Recommendation Report for Lawful Development Certificate for a Proposed Use or Development

REF NO: LU/149/15/CLP

LOCATION: 75 East Ham Road
Littlehampton

PROPOSAL: Lawful development certificate for a proposed loft conversion & extension.

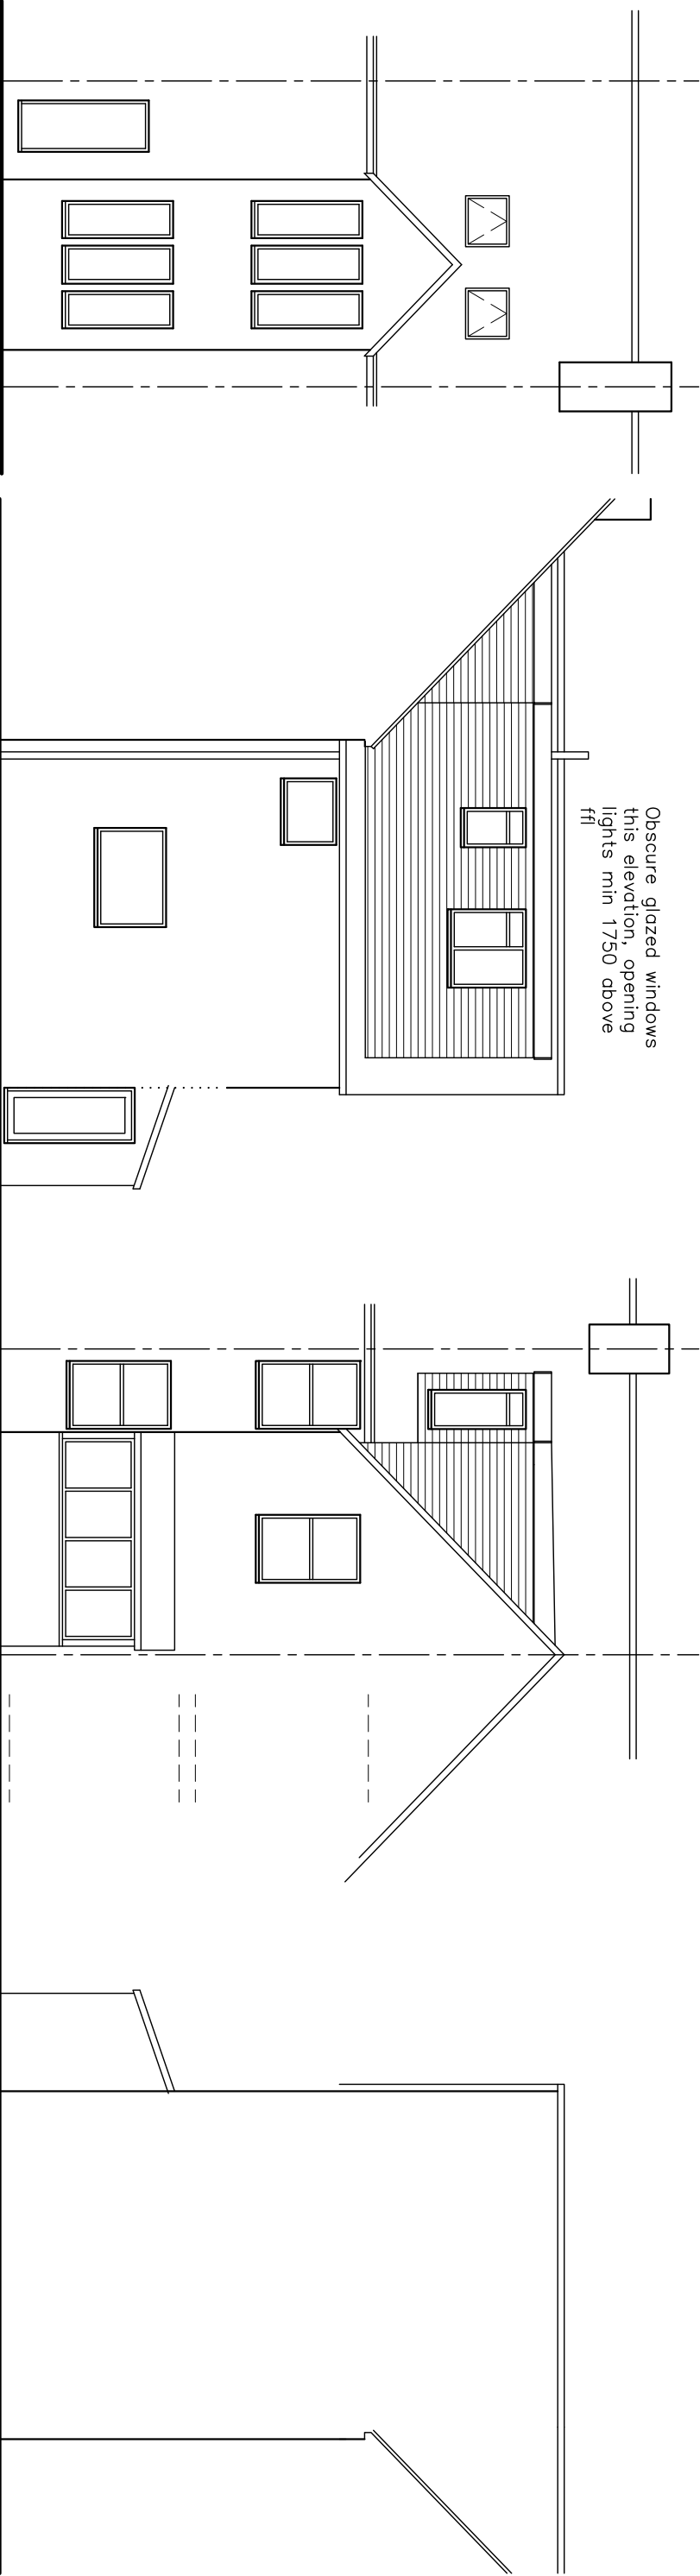
Class B, B.1 (b) states that no part of the dwellinghouse, would as a result of the works, exceed the height of the highest part of the existing roof. The proposal would not exceed the highest part of the existing roof.

Class B, B.1 (c) the dormer the subject of this application does not extend beyond the plane of any existing roof slope which forms the principle elevation of the dwellinghouse and front a highway.

Class B, B.1 (d) (i) the proposed dormer will have a cubic content of approximately 39.03 metres cubed. Therefore, the dormer does not exceed the cubic content of the original roof space by more than 40 cubic metres.

Class B, B.2, (b) (i) (ii) the design of the dormer is deemed to be in accordance with the limitations imposed under this section of Class B.

Class B, B.2, (c) (i) (ii) specifies that any windows inserted into a roof slop forming a side elevation of the dwelling house shall be obscurely glazed and non-opening below 1.7 metres from floor level of the room in which the window is installed. Drawing No 1635/01/02/A show that the windows proposed on the western elevation of the dormer will be obscurely glazed and as such in accordance with this section of the general permitted development order.
